CITY OF PORTLAND, MAINE
Department of Building Inspection

Certificate of Occupancy

4 Ledgewood Drive

TO: Inspections
FROM: Jay Reynolds, Development Review Coordinator
DATE: March 12, 2002
RE: C. of O. for # 4 Ledgewood Drive
Lead CBL (415-A-015) ID# (2001-0288)

**GRADING PLAN OF LAND
CITY OF PORTLAND
CUMBERLAND COUNTY
MAINE**

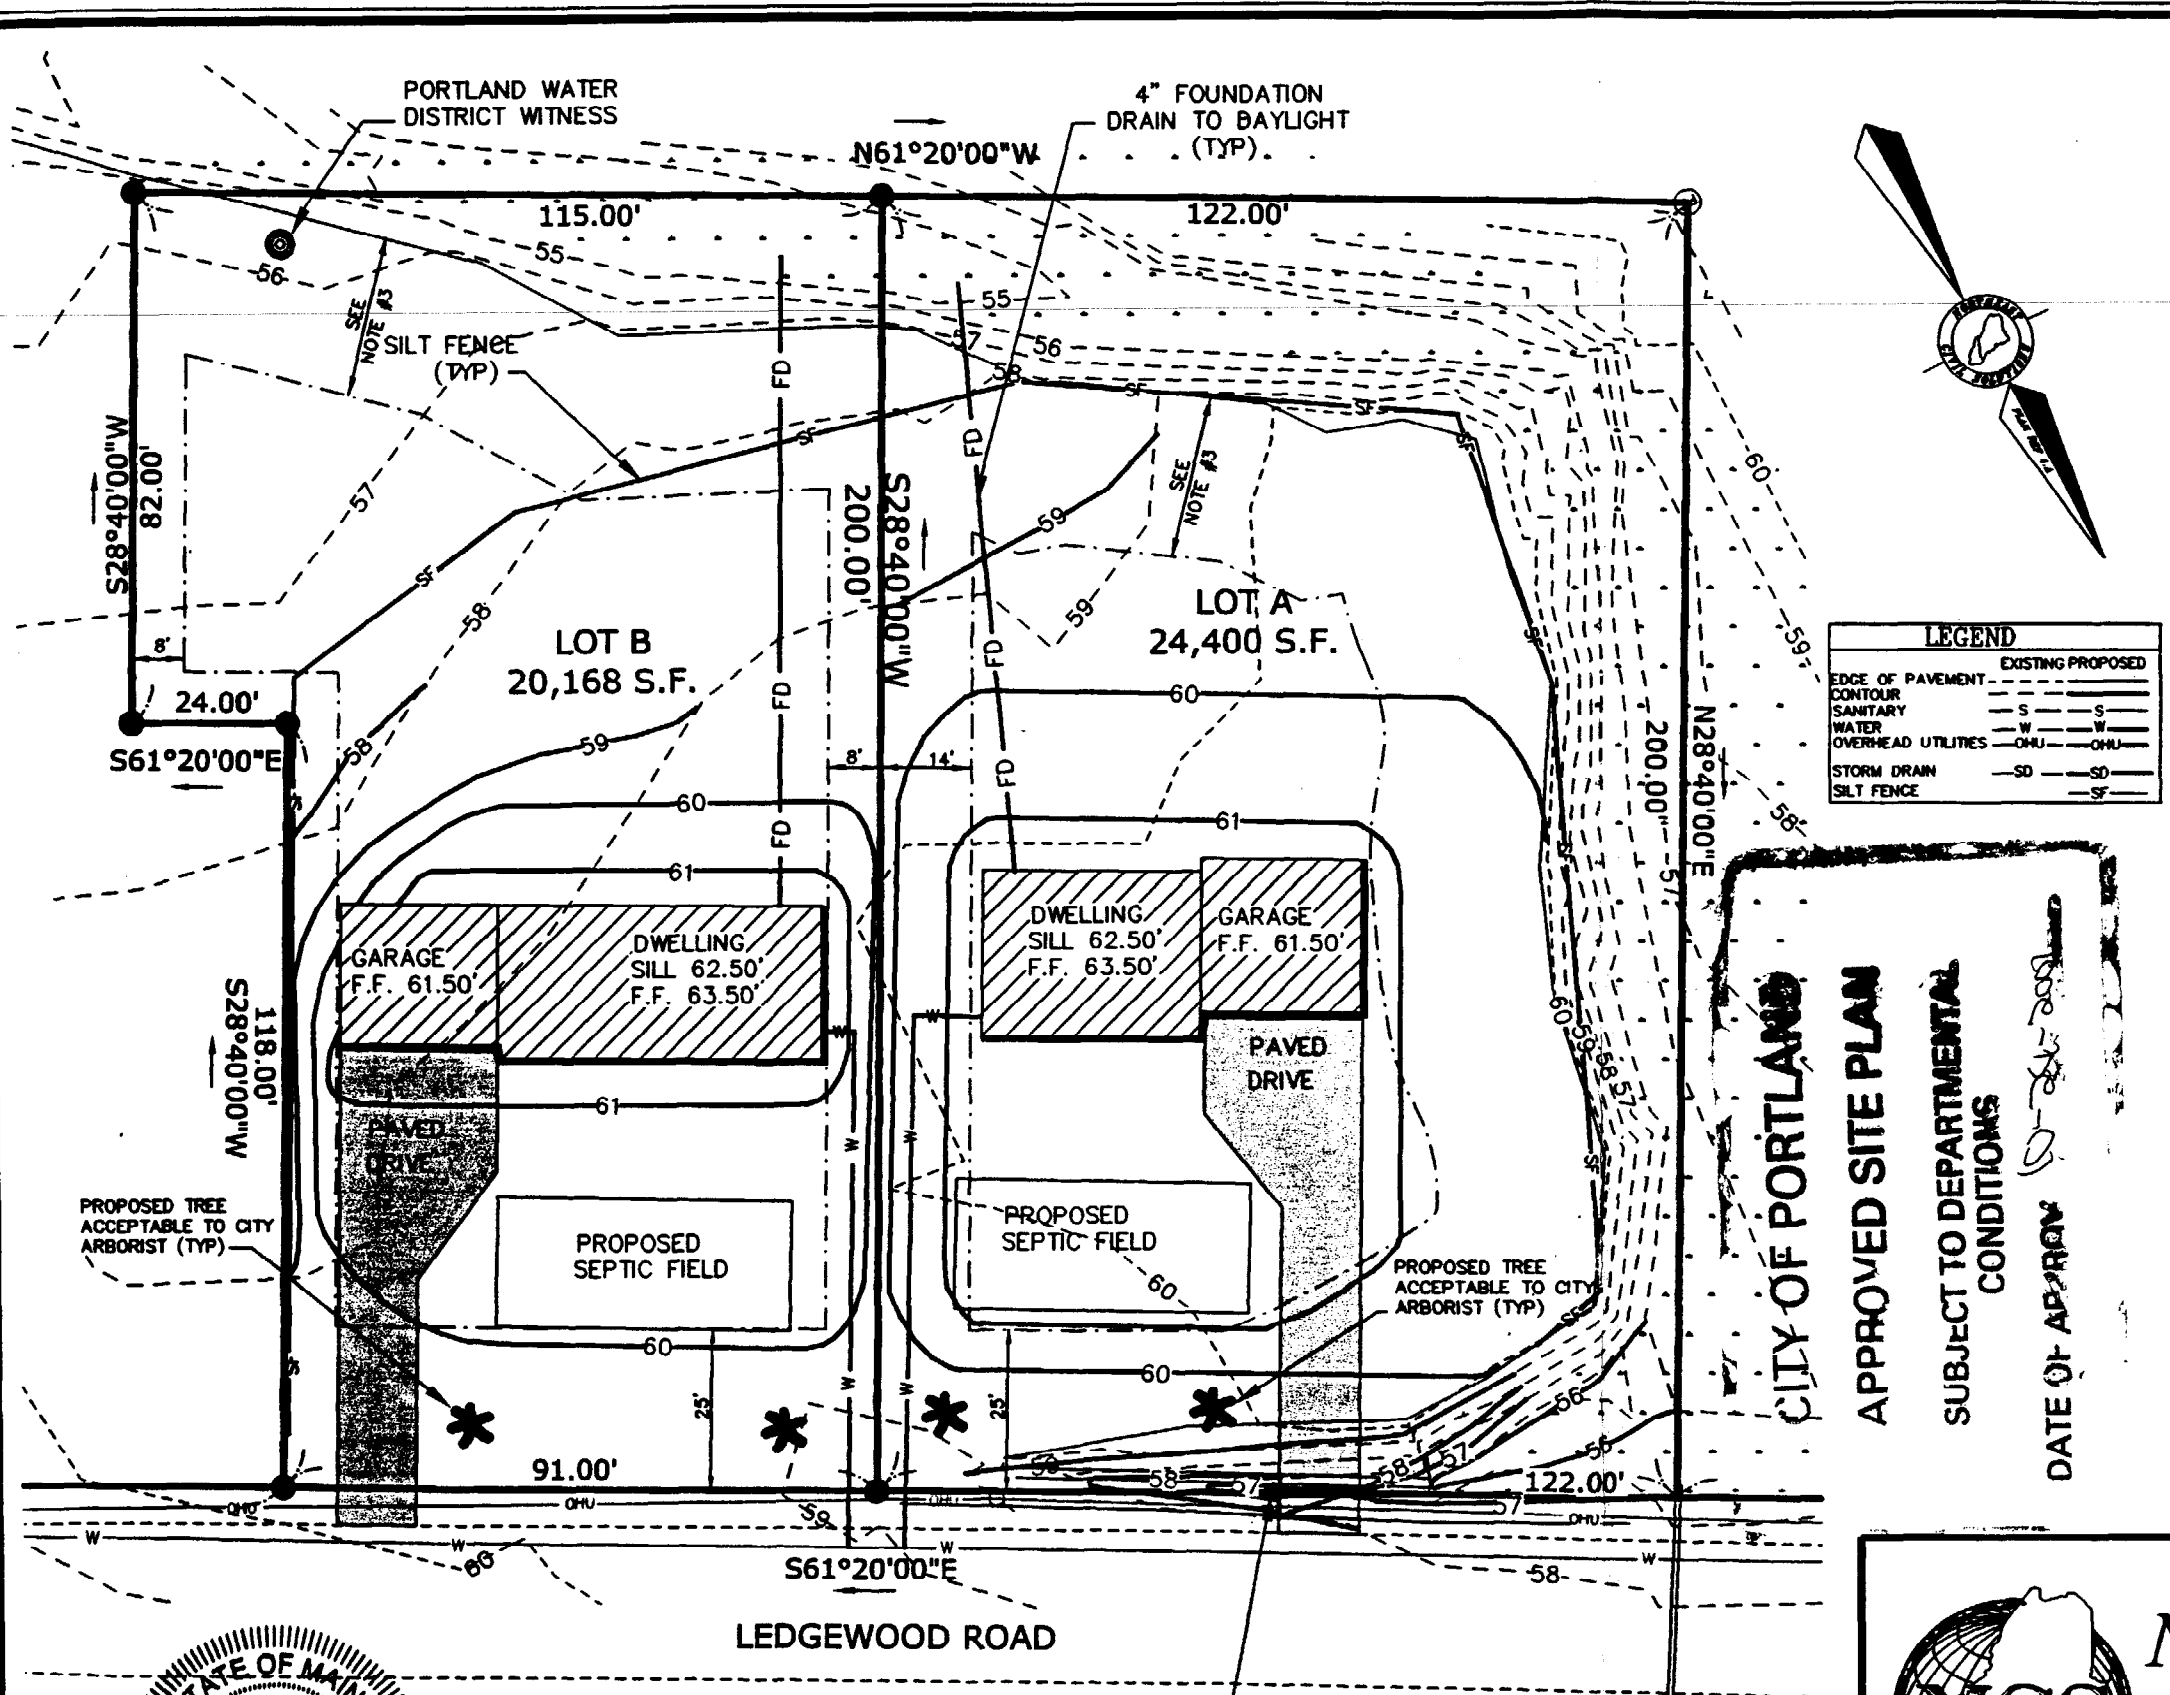
After visiting # 4 Ledgewood Drive, I have the following comments:

1. Final Grading Incomplete.
2. Loam and Seed Incomplete.
3. Landscaping Incomplete.

Due to the time of year, it is not possible to complete these items. I would estimate that these items could be completed by **June 15, 2002**. Once these items are addressed and re-inspected, then a permanent Certificate of Occupancy can be issued.

At this time, I recommend issuing a temporary Certificate of Occupancy.
